Case Officer: Will Anstey

Applicant: Eric Dier

Proposal: Variation of condition 2 (plans) of 22/01985/F - the applicant would like to play padel tennis rather than lawn tennis. This requires a change to the design approved in application 22/01985/F

Elevations – Proposed Padel Tennis Court at Adderbury Hill Barn

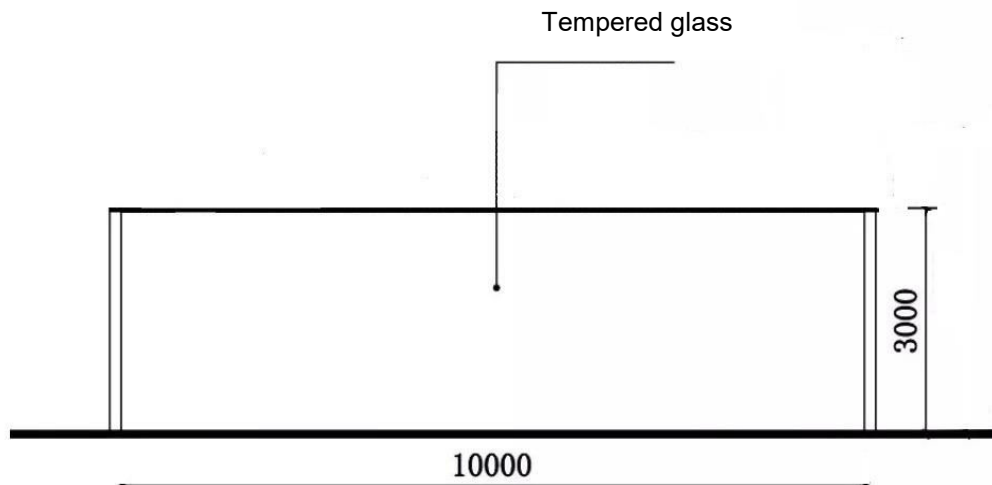
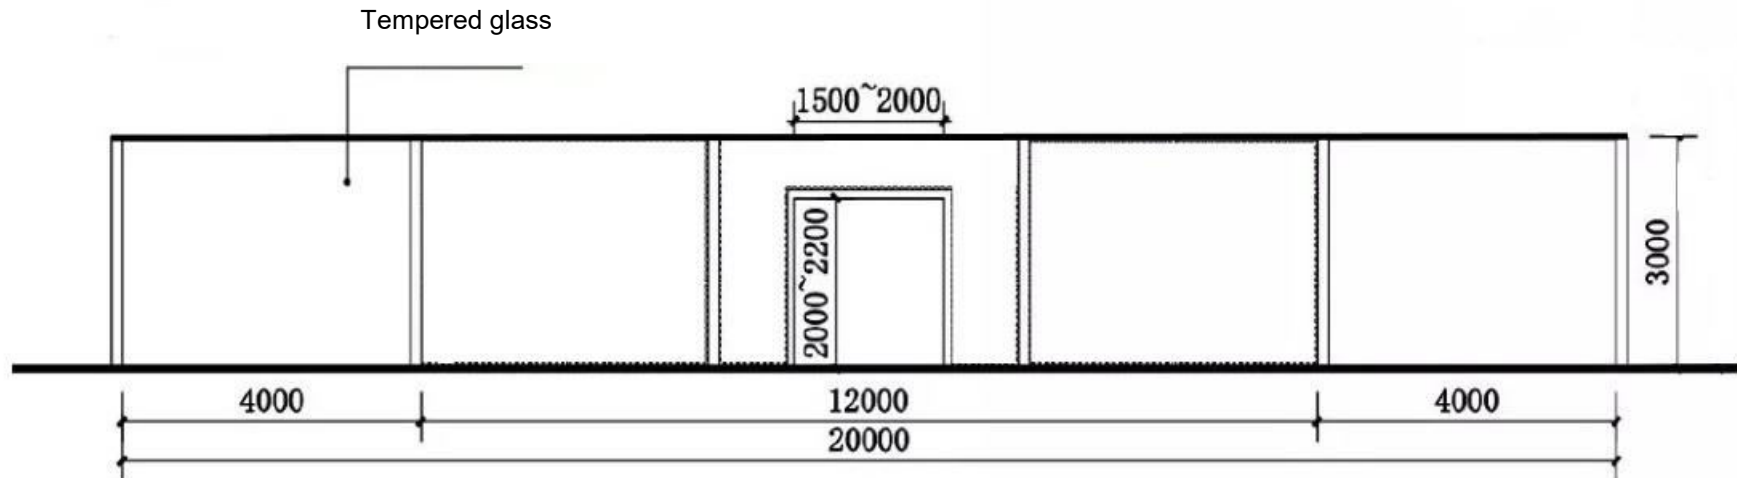
- 8.7. The proposed padel tennis court is significant smaller than the approved tennis court; however, it is also surrounded by 3m high glass walling with more substantial metal framing. Though glass is inherently transparent it can also cause significant reflections unlike the approved chain link fencing. Officers consider this would not sit comfortably within the rural landscape, especially given the additional height of the glass walling. This harm is potentially exacerbated by the more substantial framing necessary to support the glazing. Whilst the nearest public viewpoints are a significant distance from the site, given the substantial amount of glass and the visibility of reflections and glare there is potential for harm to the rural character of the area and for this to be more significant than the harm from the chain link fencing.

- 8.8. To mitigate the visual impact of the padel tennis court, the applicant proposes to sink it 1m into the ground. As such the glass walling would only appear to be 2m high when viewed from the surrounding area, thus reducing its visual impact. In addition, the applicant proposes a more substantial landscaping scheme which is possible due to the reduced size of the padel tennis court compared to the approved scheme. This would further filter views of the glass and reduce any reflections from the glazing. Whilst the landscaping is established it is proposed to erect camouflage netting on the glass which would reduce the initial visual impact of the glass. These measures all help to reduce the visual impact of the glass walls.

- 8.9. It is also relevant that under permitted development rights it would be possible to erect a 2m means of enclosure of any material on the site. Though the glass walling is 3m high, as the court would be sunk 1m into the ground it would appear as 2m in height from the surrounding public viewpoints and therefore this is a reasonable comparison.

Figure 4

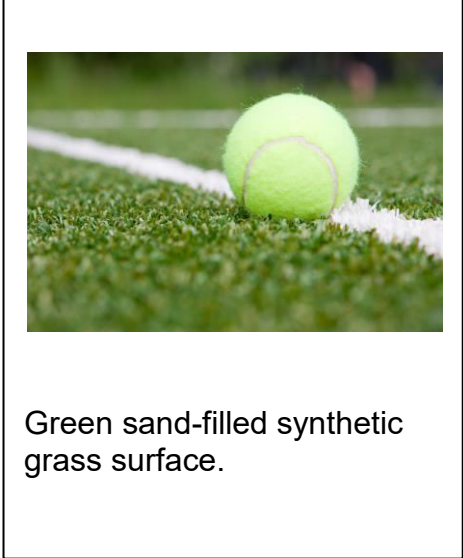
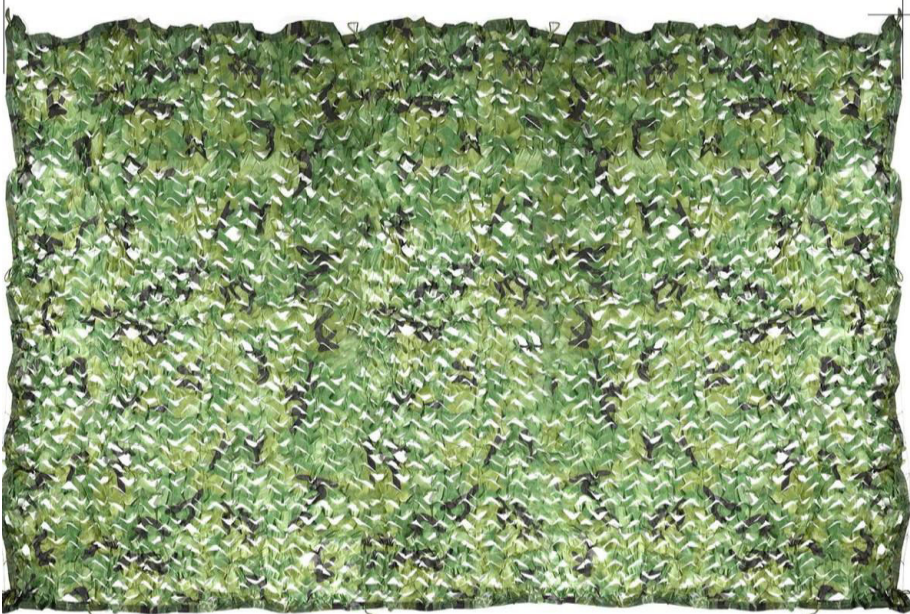
- 8.16. By virtue of its generally transparent quality, glass structures are often subject to bird strikes. Officers are concerned that the erection of 3m glass walls would be harmful to birds in the area. It is noted, however, that whilst the landscaping establishes, camouflage netting would be placed over the glass. This would reduce the initial harm from the walling. Subsequently the landscaping is shown to be planted in close proximity to the glass walling, which would reduce the perception that birds can fly straight through the glass. Officers still retain some concerns but do not consider that it would be reasonable to refuse the application on this point.

(b) details of the camouflage to be used on the padel court walling and for how long it will be installed for.

Drawing title  
LANDSCAPING TO PROPOSED POOL AND COURT

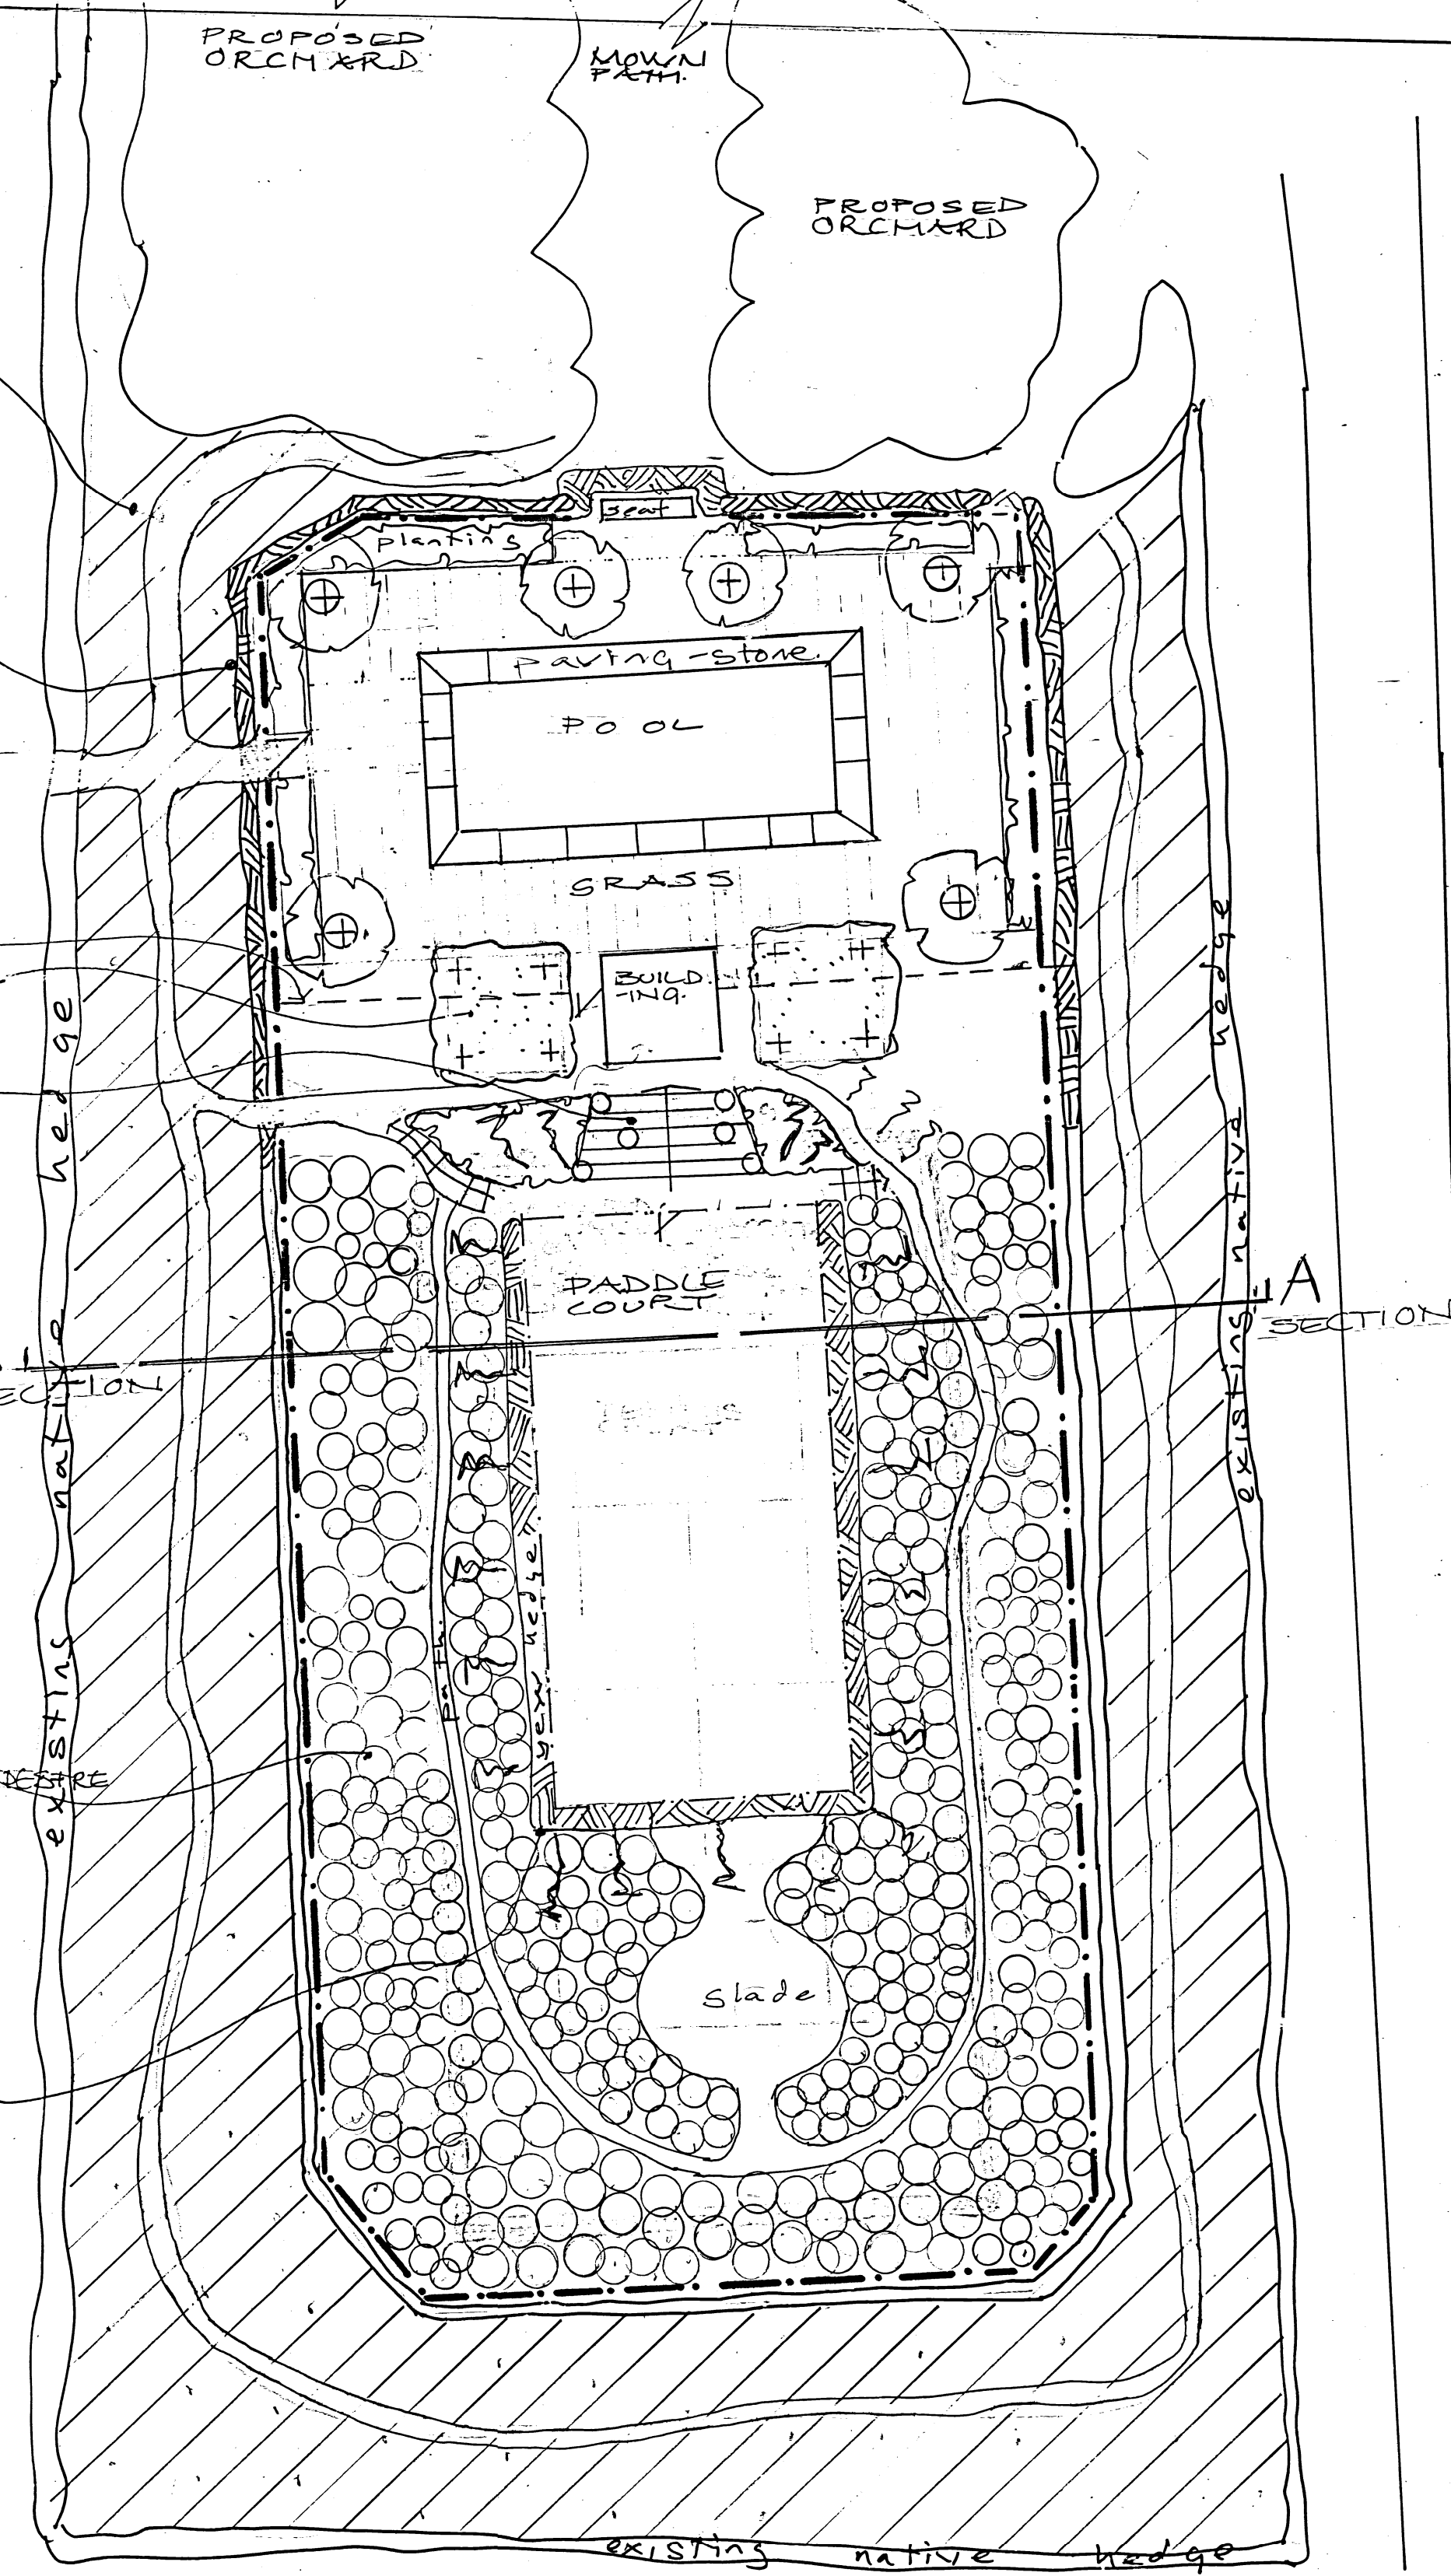
- 8.12. As before, given the importance that the landscaping plays in both softening the impact of the fencing and potentially screening the site should the fence be removed, it is considered necessary to impose a condition seeking further details of the landscaping and a maintenance plan to ensure landscaping is maintained after planting.

3. A scheme for landscaping the site shall be provided to and approved in writing by the Local Planning Authority which shall include:-

(a) details of the proposed tree and shrub planting including their species, number, sizes and positions, together with grass seeded/turfed areas and written specifications (including cultivation and other operations associated with plant and grass establishment i.e. depth of topsoil, mulch etc),
